**Project:** Prince Place Lot 21  
**Location:** Fuquay Varina, NC  
**Company:** David Homes  
**Care Of:** Lee Aversano  
**Subject:** Roof Truss Repairs  
**Job Number:** 2-2670-22

As requested, Andy Takla, PE visited the above referenced site on June 6th, 2022 to review the damage and provide repair / modification recommendations to the following roof trusses:

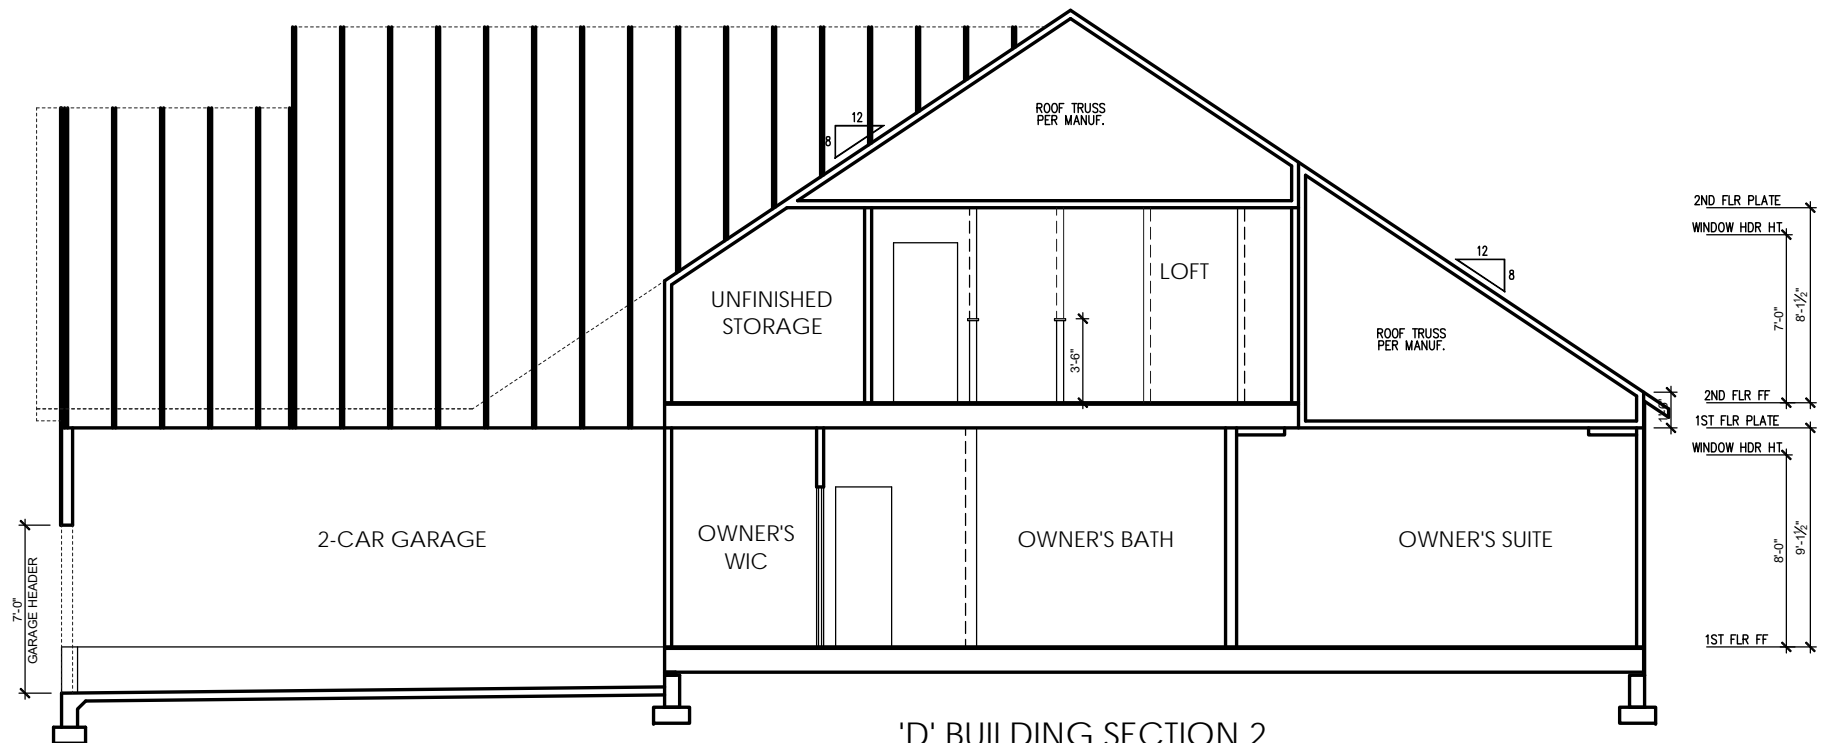
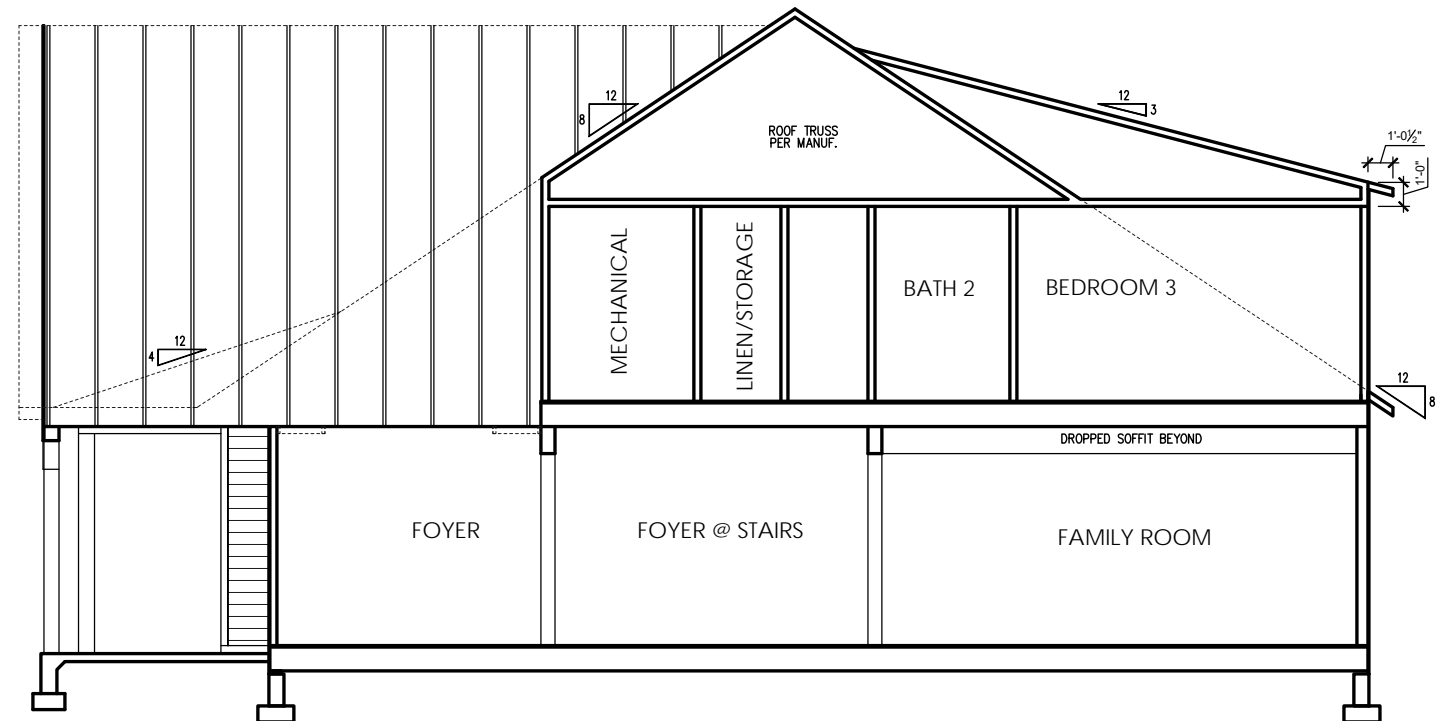
1) One (1) B3 roof truss which aligns directly over the 2nd story chase which will house the fireplace duct will need to be cut (to accommodate the duct). Moving forward we recommend installing 6' long 2x4 scabs to both sides of the bottom chord both forward and rear of where the duct will run (+ minimum 2" gap). Continue to pack out these 6' long 2x4s, attaching with (2) 10d nails at 3" on center until duct is cleared. Then, install a ~13' long 2x4 scab to both sides of the truss and packing, centered on the duct and attach similarly.

2) The three (3) left most roof trusses near the left wall features damaged vertical webs serving as the forward wall of the 2nd story. See picture below for reference. Moving forward we recommend the following:

- A) cut damaged portions of broken webs away as to provide a clean, flush end.
- B) Fill in the missing portions of the web with field framed 2x4 material.
- c) Install a 4'x4'x1/2" OSB gusset plate to both sides of the top and bottom chord joints, notching away only the material required to not intrude into finished areas. Attach with (2) 10 x 1.5" nails spaced at 3" on center to all adjoining truss and field framed members.
- D) Install a full length 2x4 scab extending from top of top chord to bottom of bottom chord to both faces of the truss (+ gusset plates). Attach with (2) 10d nails at 3" on center.
